Our Ref: TR010030

### **Application by Highways England for an Order Granting Development Consent for the M25 Junction 10/A3 Wisley Interchange**

#### **Advice following issue of decision to accept the application for examination**

SHEET 2 OF 31

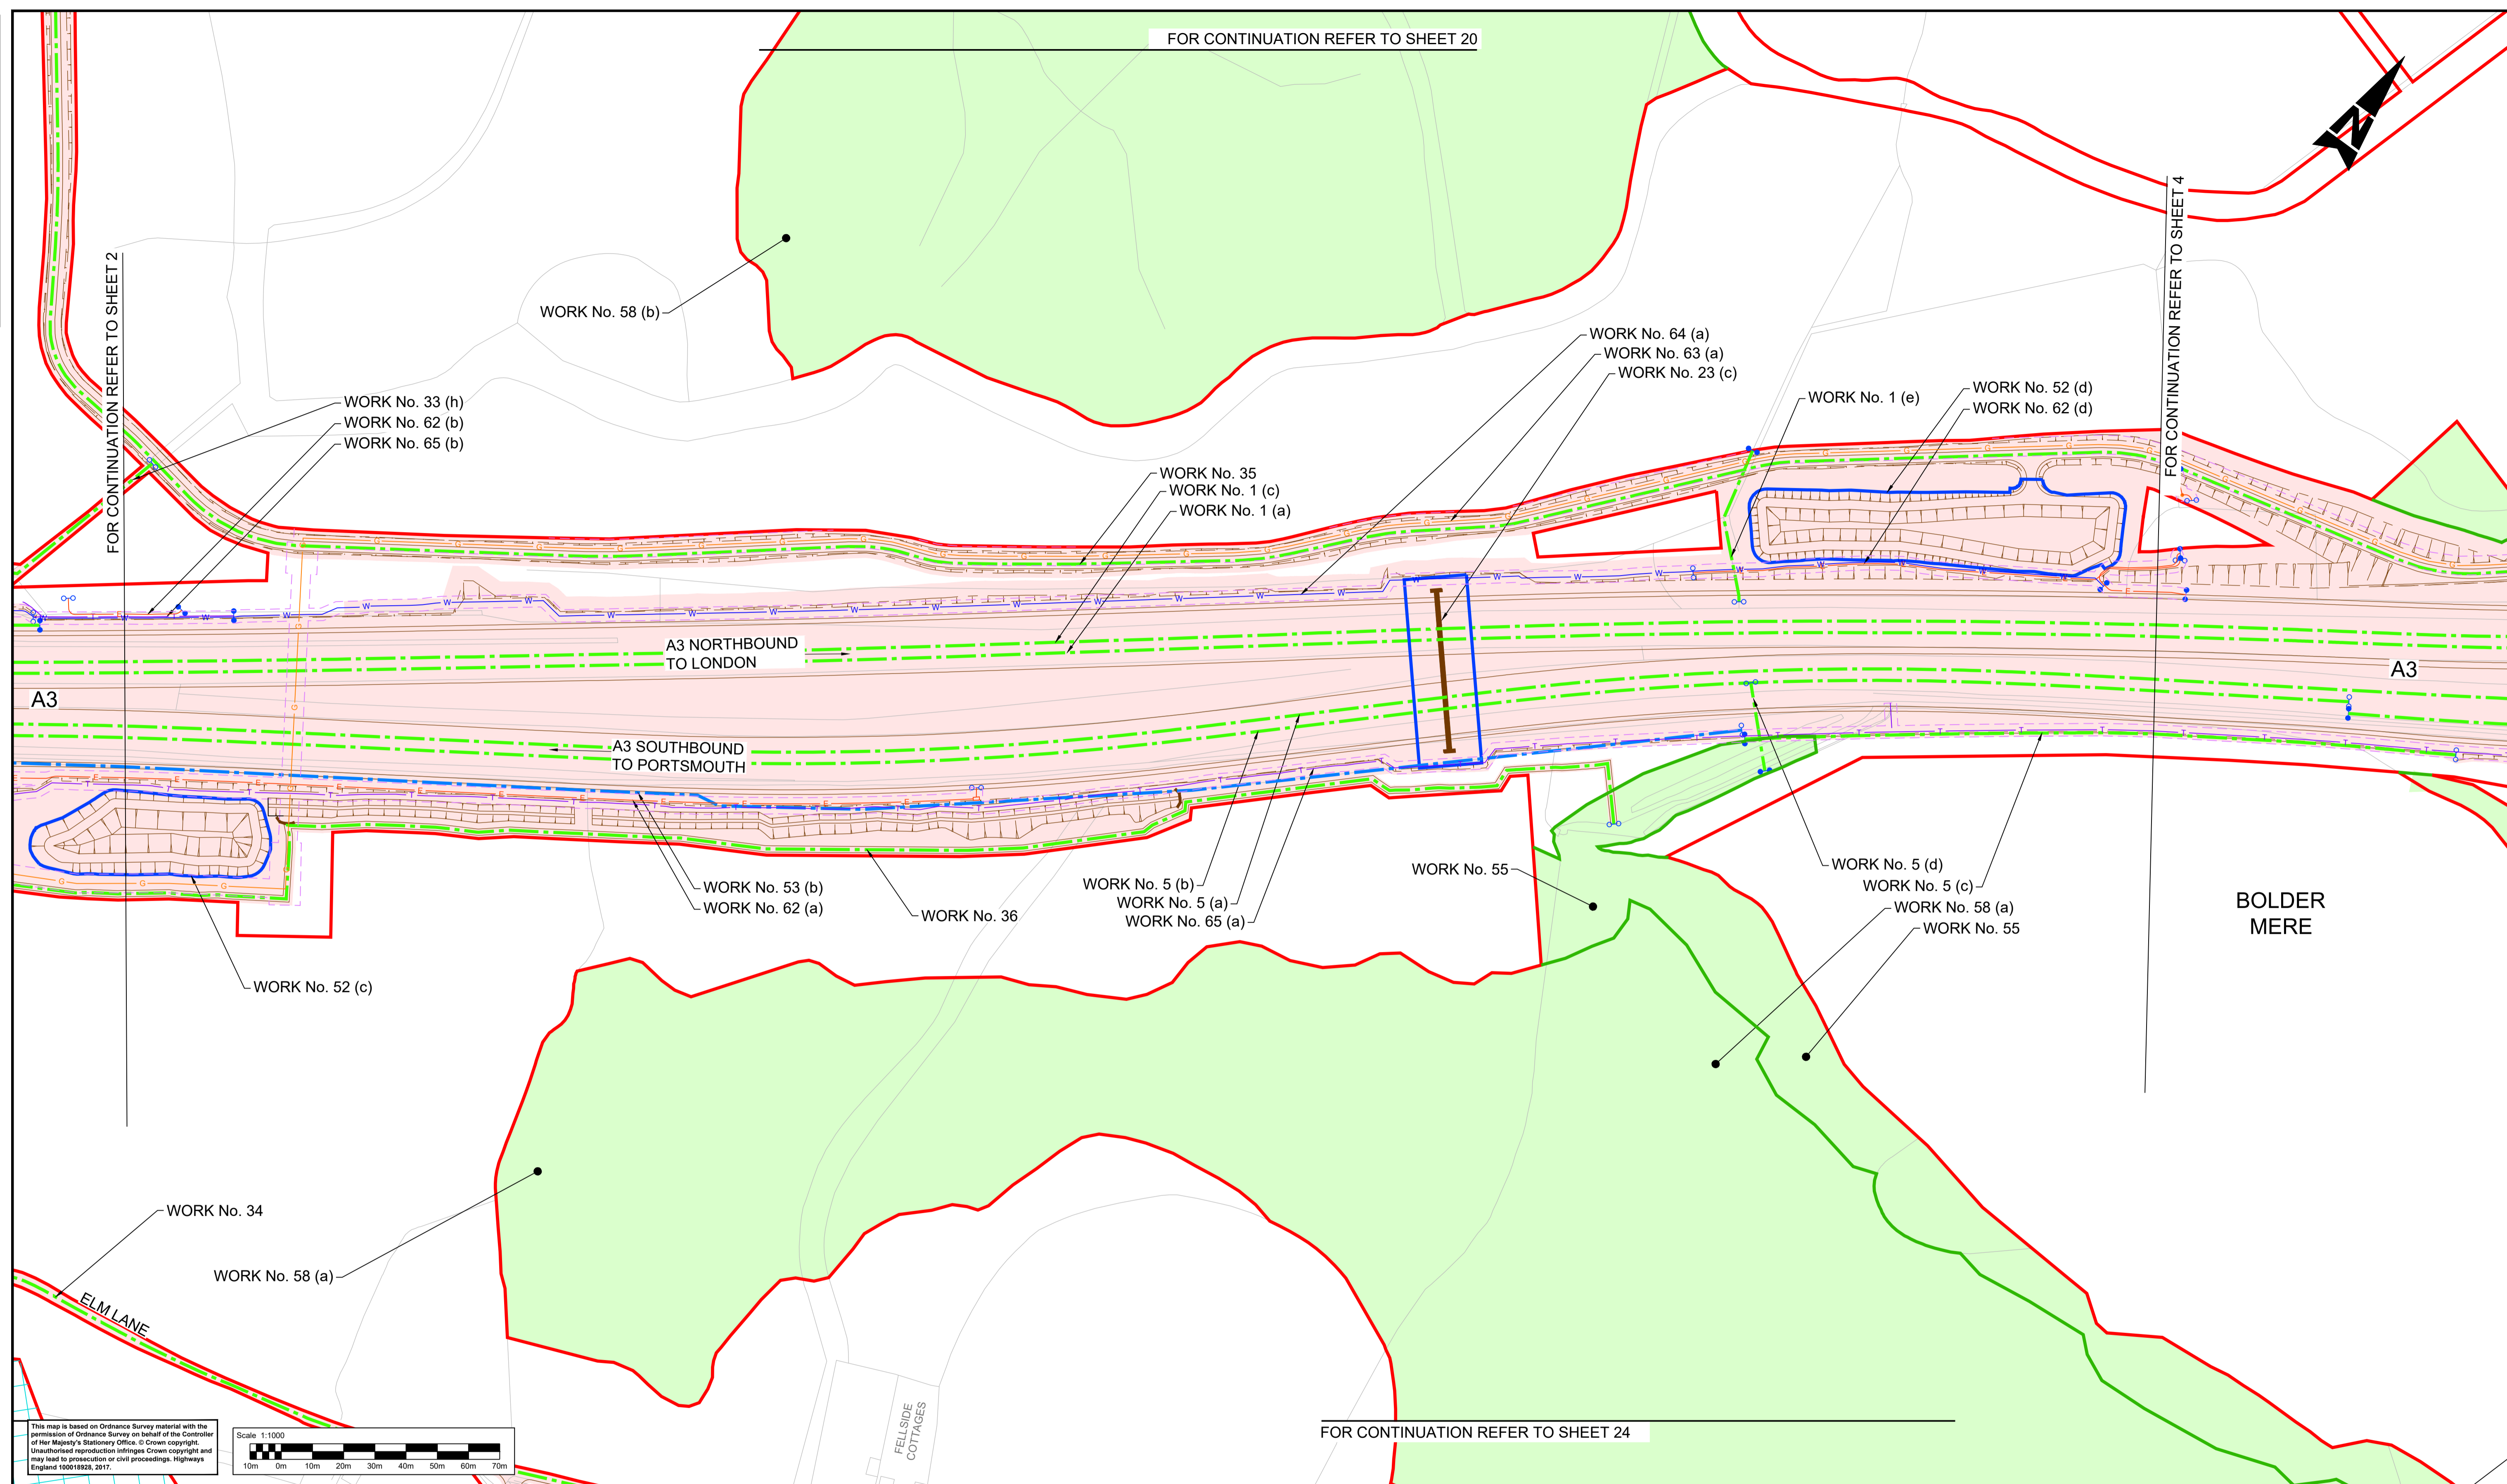
The format of work number 35/35 (k) on sheet 7 looks incorrect.
